Application Reference: 2025/0436

Site Address: 95 Strafford Avenue, Elsecar, Barnsley, S74 8AL

Introduction: Erection of 2 sheds to use as workshop and games room.

SIDE FACING SOUTHERLY

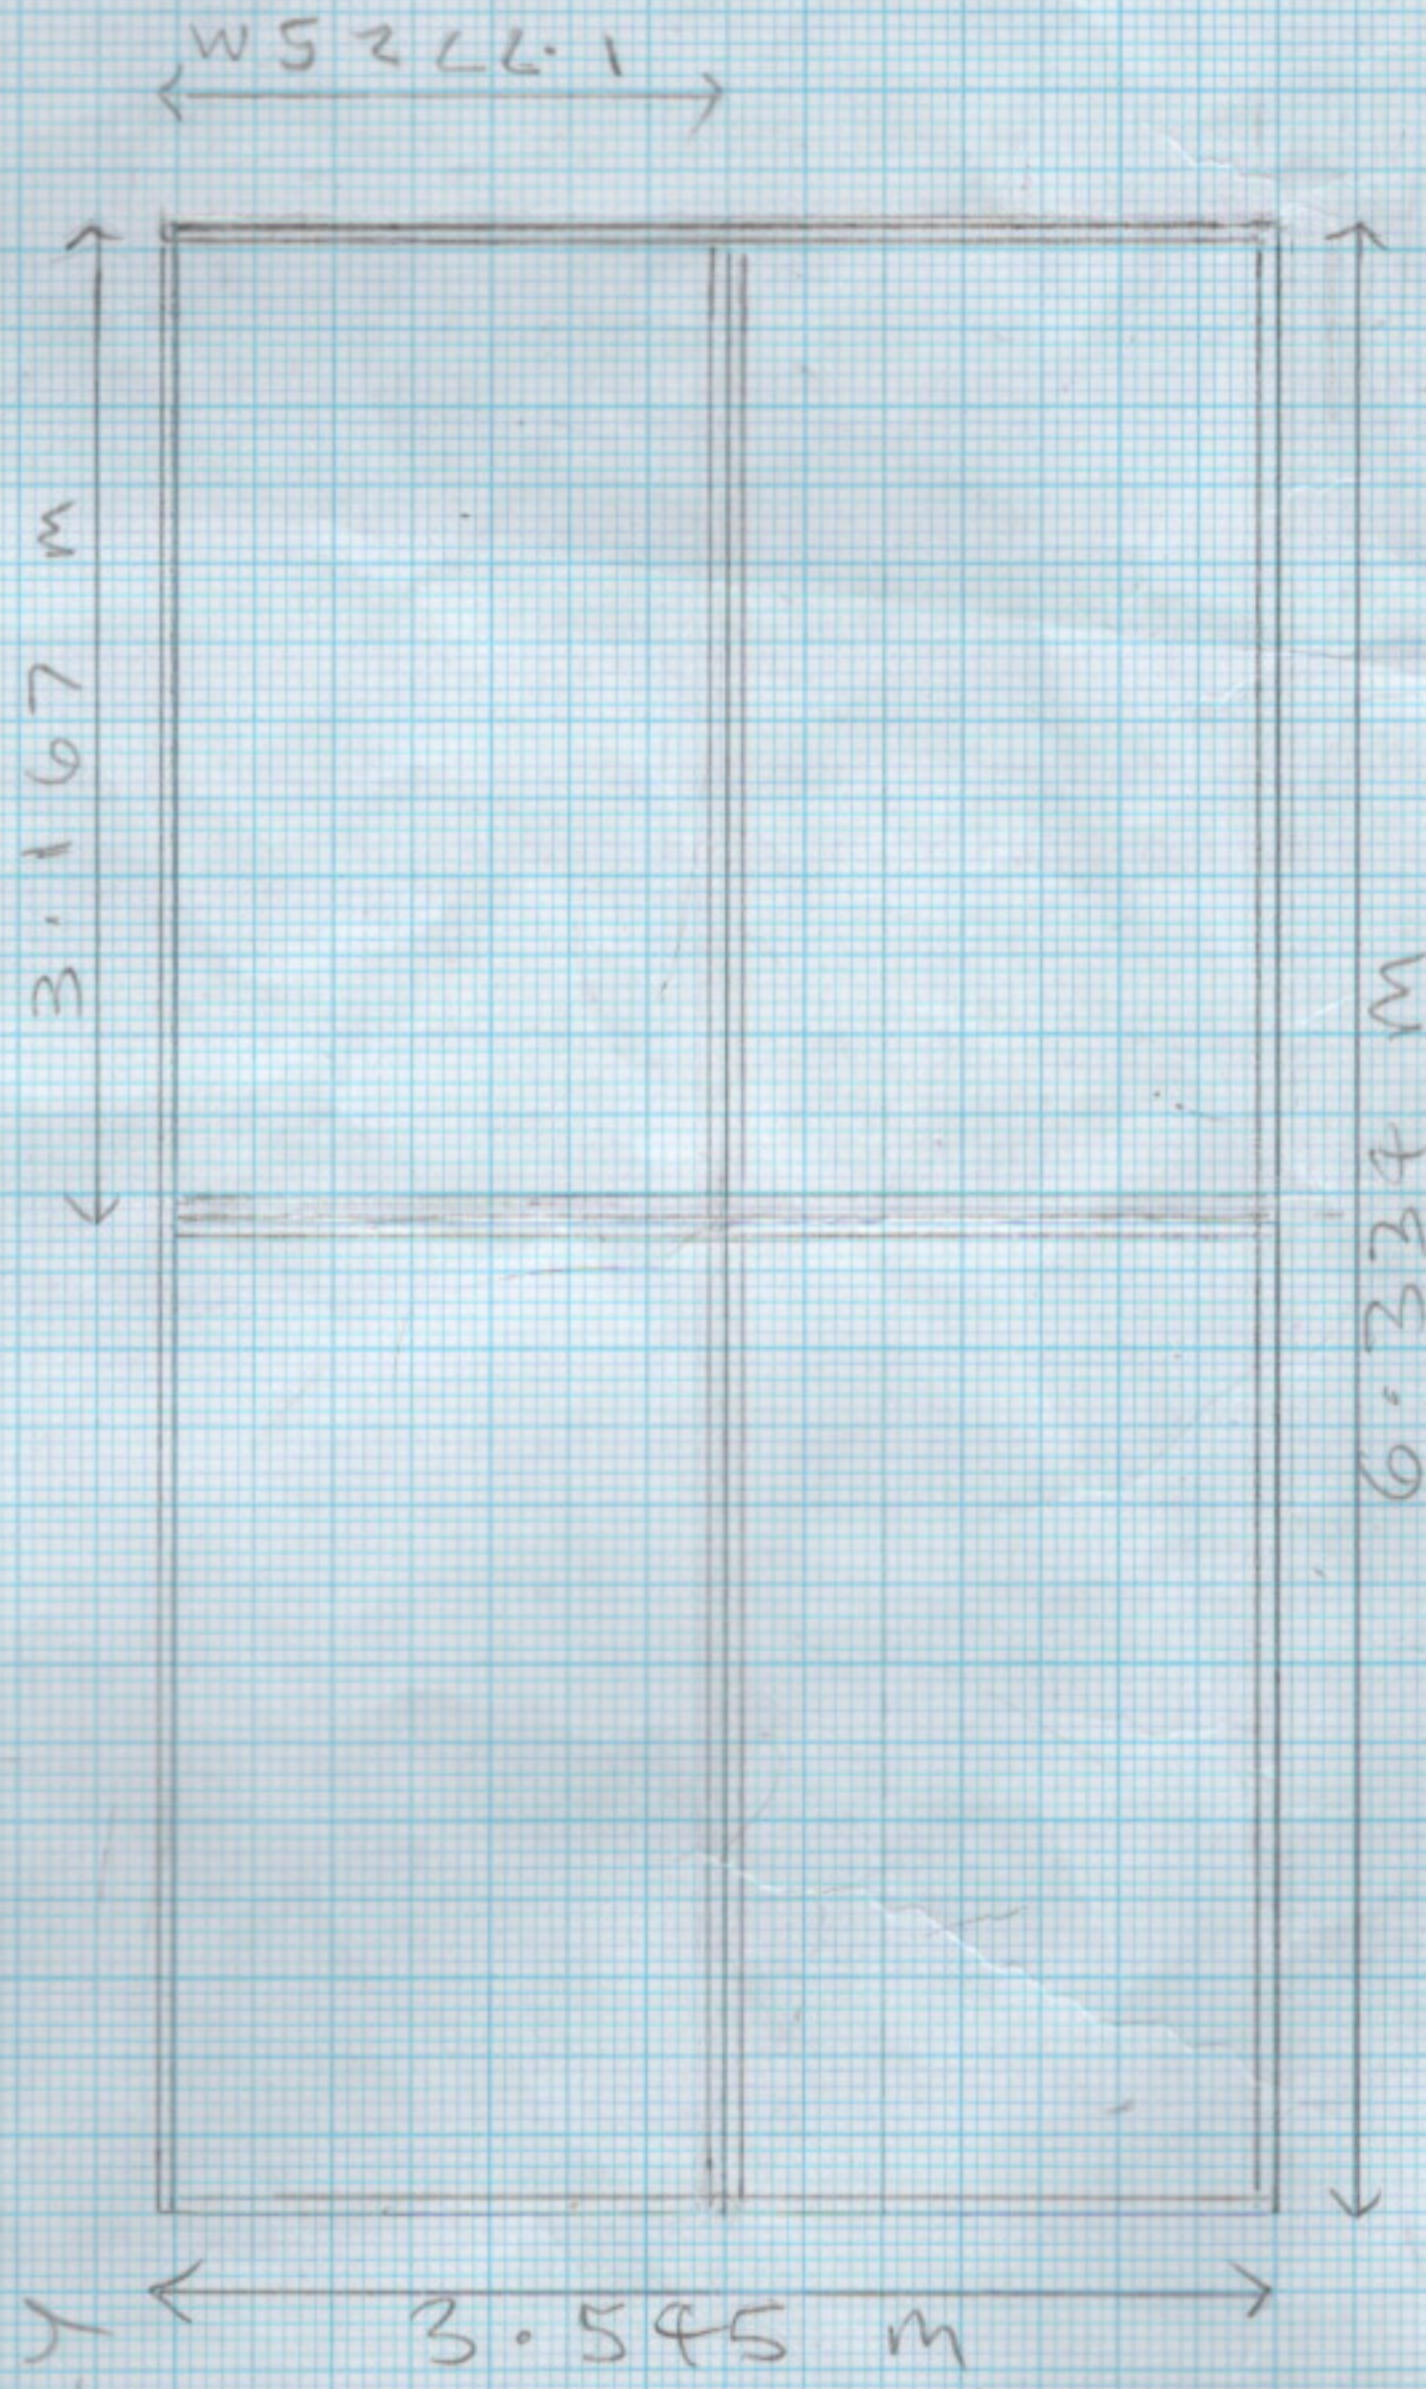
The New Games Room would have an approximate floor space of 14.9 square metres, an approximate roof height of 2.77 metres and an approximate eaves height of 2.25 metres. A pitched roof has been detailed. Four elongated windows are detailed to the east elevation of the outbuilding, two either side of the proposed doors spanning 1.64 metres. Three elongated windows are detailed the north side elevation and three to the south side elevation. The outbuilding would be constructed from timber.

The proposed two proposed outbuildings would be erected within close proximity to the neighbouring boundary to the west. The size and scale of the outbuildings are not likely to cause any issues in terms of loss of light or outlook. The height of approximately 2.77 metres is less than the maximum 4 metres for outbuildings as outlined within the House Extensions SPD and the eaves heights of approximately 2.26 and 2.26 metres is also less than the maximum eaves height of 2.5 metres. These heights are not significantly greater than the existing boundary treatment and would not be impactful enough to cause detrimental harm to loss of outlook and sunlight.

The proposed new outbuildings are detailed to a scale in line with the House Extensions SPD. The height of approximately 2.77 metres is less than the maximum 4 metres outlined within the House Extensions SPD and the eaves heights of approximately 2.26 and 2.26 metres is also less than the maximum eaves height of 2.5 metres. The use of wood materials does not match the material of the site dwelling, however wooden sheds are common feature of residential gardens and are not considered detrimental to the character of the site, especially given they cannot be seen from the street scene.

The addition of the proposed new outbuildings would increase the cumulative floor space to approximately 81 square metres, approximately 69% of the total curtilage. Given the accumulation of the floor space taken up by the existing outbuildings and the proposed new outbuildings, it is considered the development at the site to be excessive and to take up a disproportionate amount of private rear garden space. It is acknowledged the erection of the two proposed outbuildings has begun but is not yet completed.

It has been necessary to make contact with the applicant to request plans and elevation of the proposed New Workshop and New Games Room in order to obtain more accurate roof and eaves heights for accurate assessment of the proposal. This information was provided and resulted in amended plans and elevations.

In the opinion of the local planning authority, the cumulative impact of the erection of two new outbuildings for use as a workshop and games room alongside several existing outbuildings would result in a disproportionate amount of the rear garden being developed. The cumulative impact of the existing and new development would also have an overtly dominant impact on the character of the application dwelling to the detriment of visual
